Please could you upload the e-mail below and the attachment to the application folder BE/70/20/DOC as additional drainage information?

Subject: RE: RE: BE/70/20/DOC Drainage Planning Comments

Condition 6- surface water drainage design

PHASE 1A - LIDL SITE
DRAINAGE LAYOUT

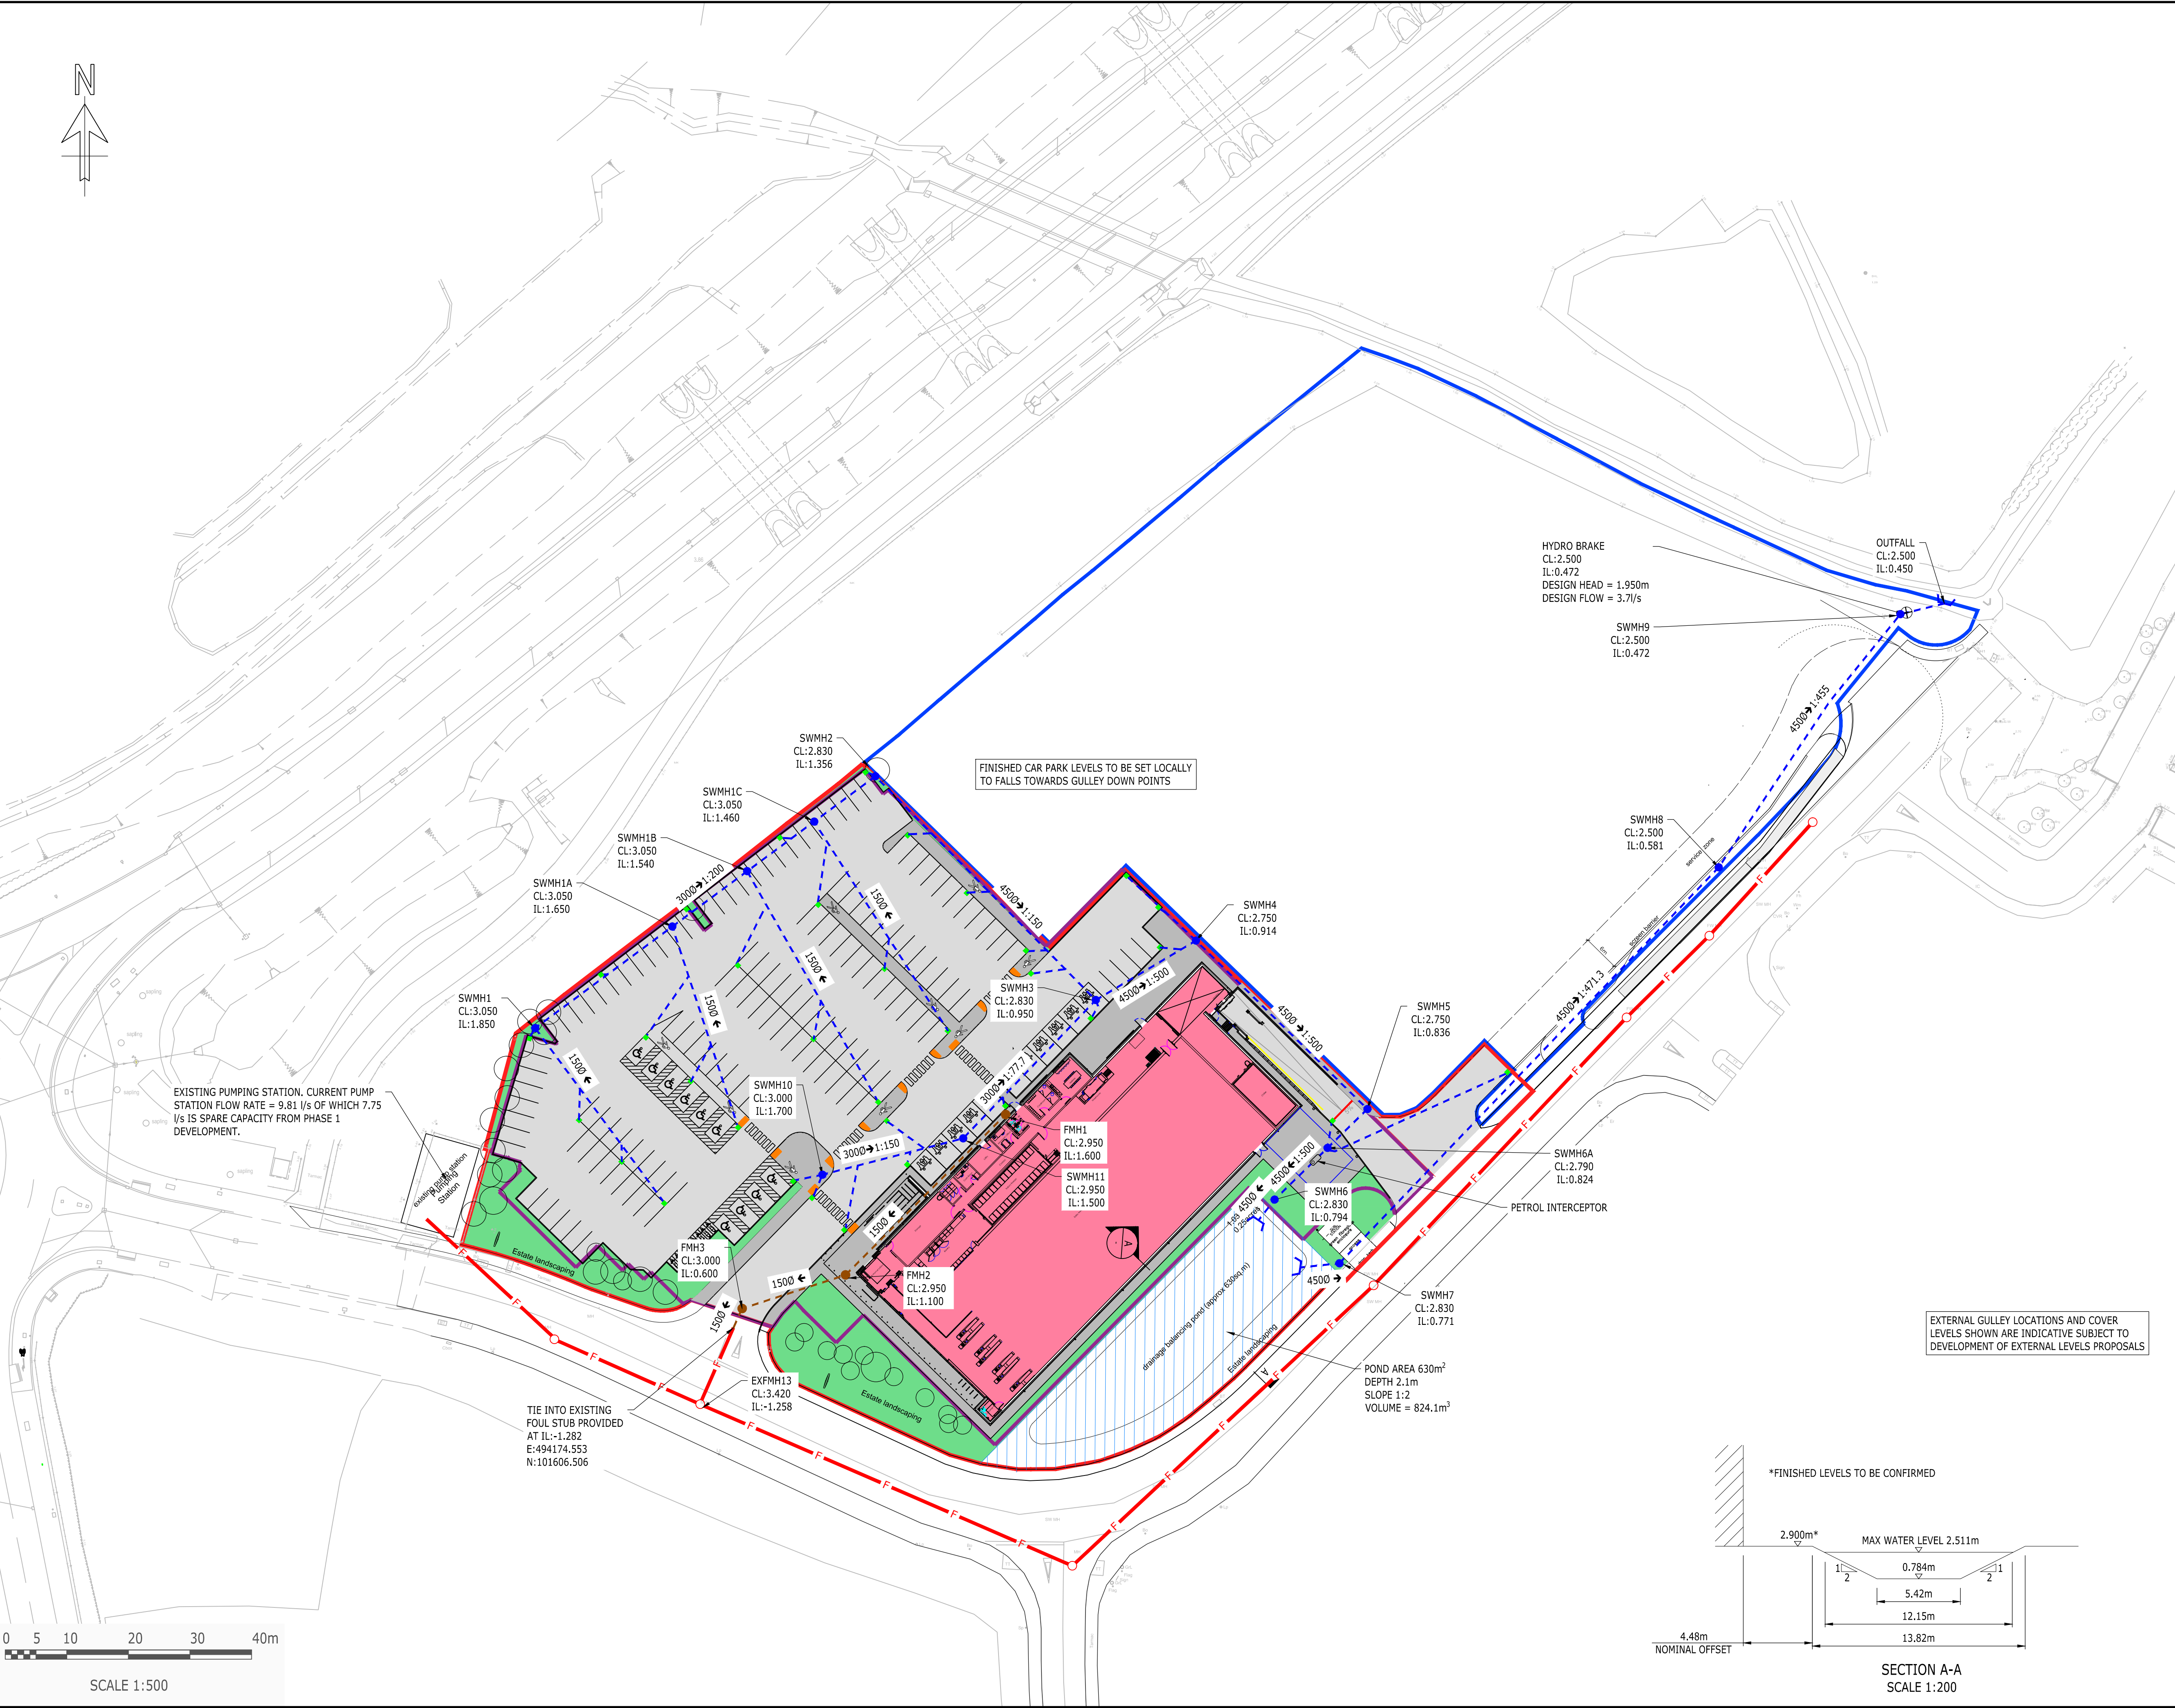
2. Please model a surcharged outfall with water levels set to adjacent top of bank level as a conservative assumption. This will invalidate the original drainage design simulations that were already reviewed by ADC. In any case I have attached print outs for both with and without surcharged outfalls. It is noted that with surcharged outfall no flooding occurs for 1 in 30 yr +40% but approx. 22m³/s occurs at the outfall for the 1 in 100+40% storm. For the originally submitted simulation reviewed by David as part of the strategy document no flooding occurs for all storm scenarios. *A surcharged outfall must be modelled, wet winters will see high water levels within the ditches.* This is a large volume of flood water. Can pipe diameter be increased, or more storage be provided upstream, see comment 8 re permeable paving.
As per previous microdrainage output provided we will retain the surcharged outfall and provide storage upstream in order to remove this flooding. Additional storage will be in the form of cellular storage tank within the car park in order to remove the flooding experienced at the outfall.

4. We note that MicroDrainage has been set to autodesign pipes to achieve 0.75m/s, 1 m/s must be achieved. Please include a printout from MicroDrainage indicating velocities achieved in pipes. As per point 2 original design submitted and reviewed was set to 0.75m/s and was not requested to be increased to 1m/s as part of the comments raised by David. We are working to fairly constrained site levels and as such do not believe this is achievable in the current system. The maintenance schedule provided will ensure these pipes are cleansed accordingly in any case. *Pipes must achieve 1m/s, we note that the majority of pipes are achieving circa 0.9m/s as per MicroDrainage printout. Please review design.*
We will review the pipe falls and increase as best we can to achieve 1m/s. Note, we currently have 250mm freeboard above the ditch connection point this will likely reduce in order to increase velocities. However, it is noted minimum freeboard of 100mm will still be required as per previous ADC comments. This may also result in more storage being required due to the velocity at which flow moves through the network. This will also be achieved through additional cellular storage provided upstream with appropriate flow controls (orifice or similar).

Just to follow up on the below I have remodelled the network to incorporate, no flooding for the required storm event, 1m/s for the carrier drain runs and surcharged outfall as requested. Note, the green areas including pond area are included within catchment.

PHASE 1A - LIDL SITE
ATTENUATION POND DETAIL

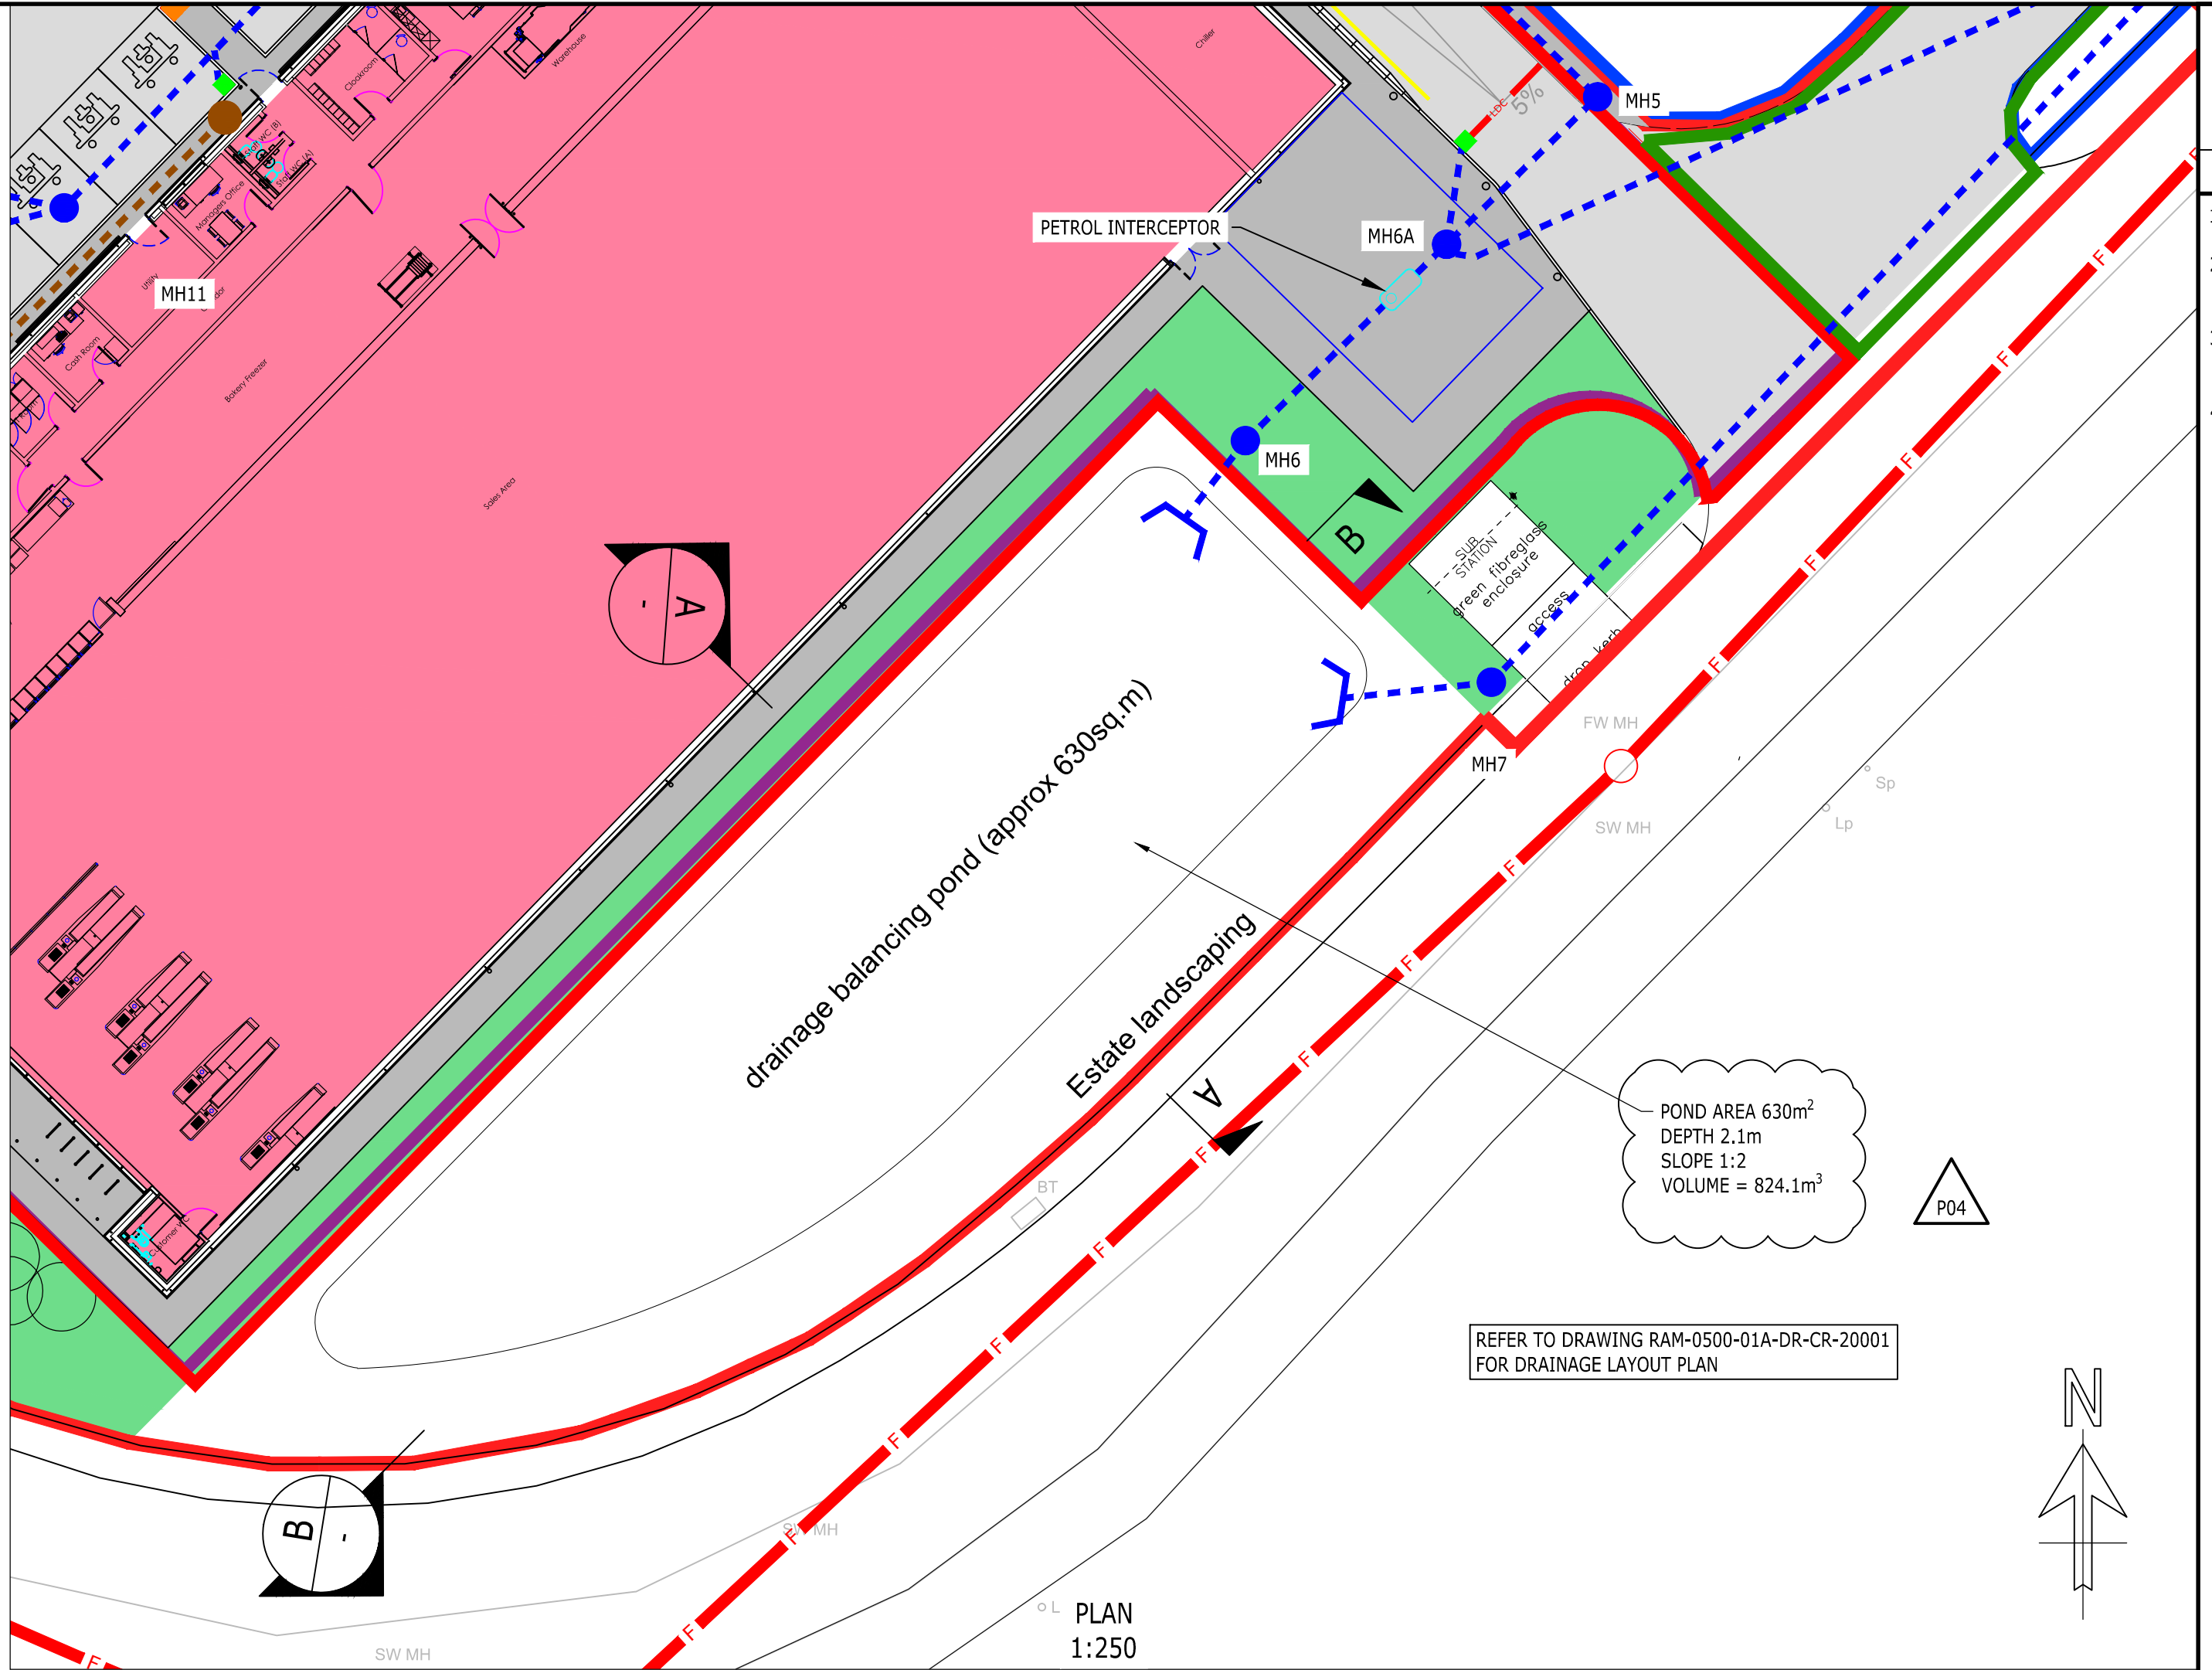
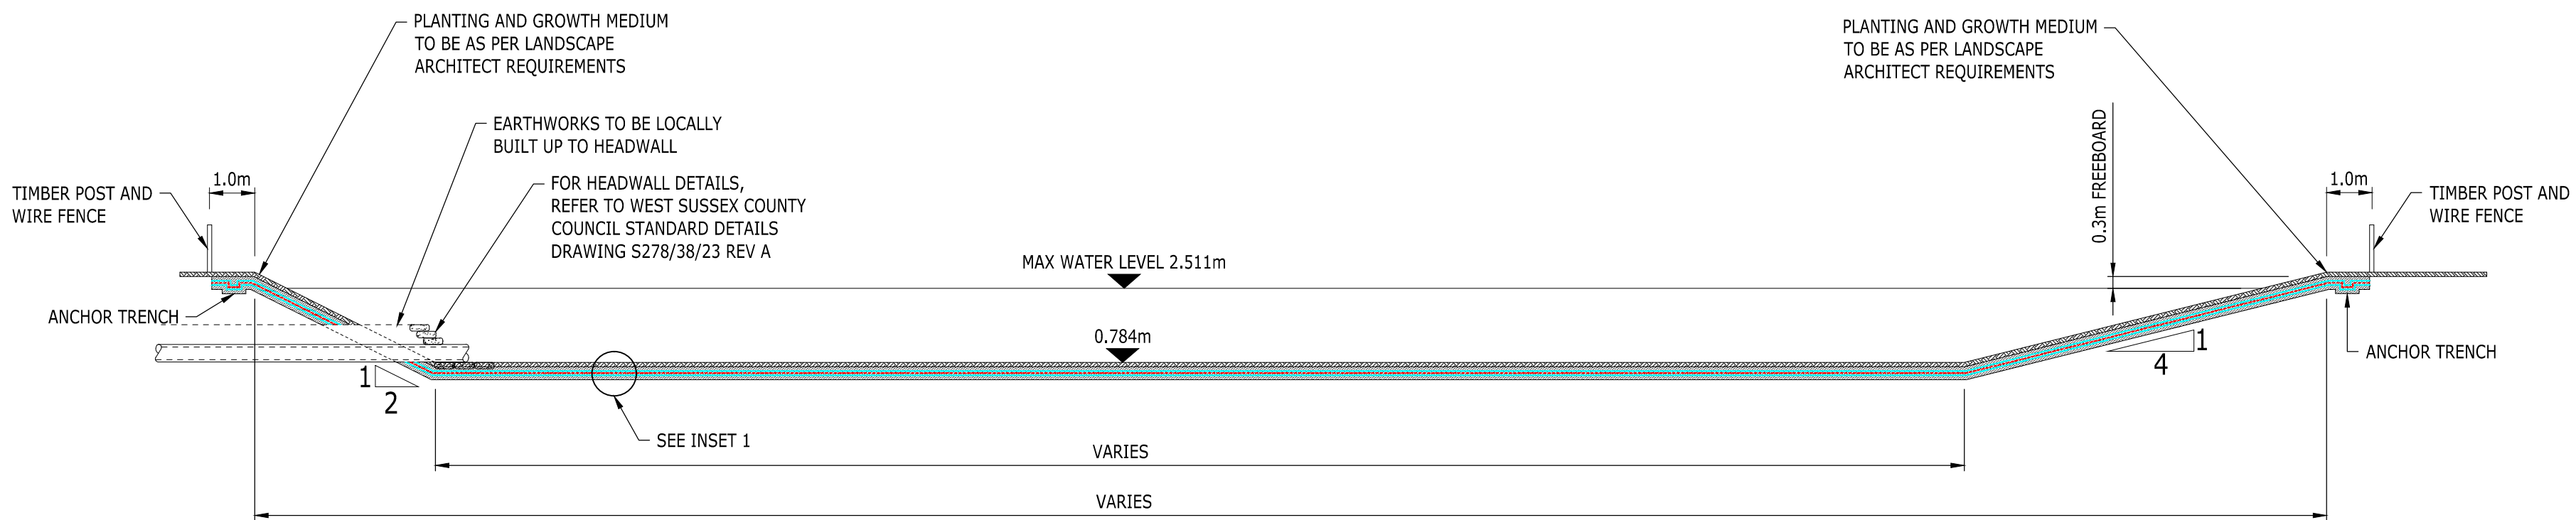
5. Pond cross sections have been provided, these indicate slopes are to be set to 1:2. 1:3 slopes should be provided. As per point 2 this pond cross-section was proposed and shown to ADC previously and no objection received. We have no further space in the area of the pond to alter to 1 in 3 side slopes as this would reduce the overall storage volume and cause flooding. *Can any slackening of slopes occur, please see comment 8 below where additional storage is suggested. You have room on site to provide additional storage, you are just opting not to currently.*
We do not believe we can slacken the pond side slopes any further as the impact on storage would be to drastic and no further space is available to expand the pond area. Considering this is our main storage component we believe the 1 in 2 side slopes should be retained and we can make reference to the 1 in 2 side slopes in the maintenance manual so care is taken during any maintenance procedures.

6. It appears that a post and rail fence is proposed 1m from the top of bank of the attenuation basin. We require a 3m clear buffer around the basin to facilitate future maintenance. 3m easement has been provided in regard to distance to any structures. The post and rail fence has been provided as a safety measure to prevent access. Although this is within the 3m it is thought it would be best to keep this and maintenance can still be carried out by the private maintenance consultants. *Maintenance manual should acknowledge the location of this feature and the potential requirement for its dismantling and reconstruction to complete maintenance.*
Noted, we will update the Maintenance Manual to ensure this is mentioned.
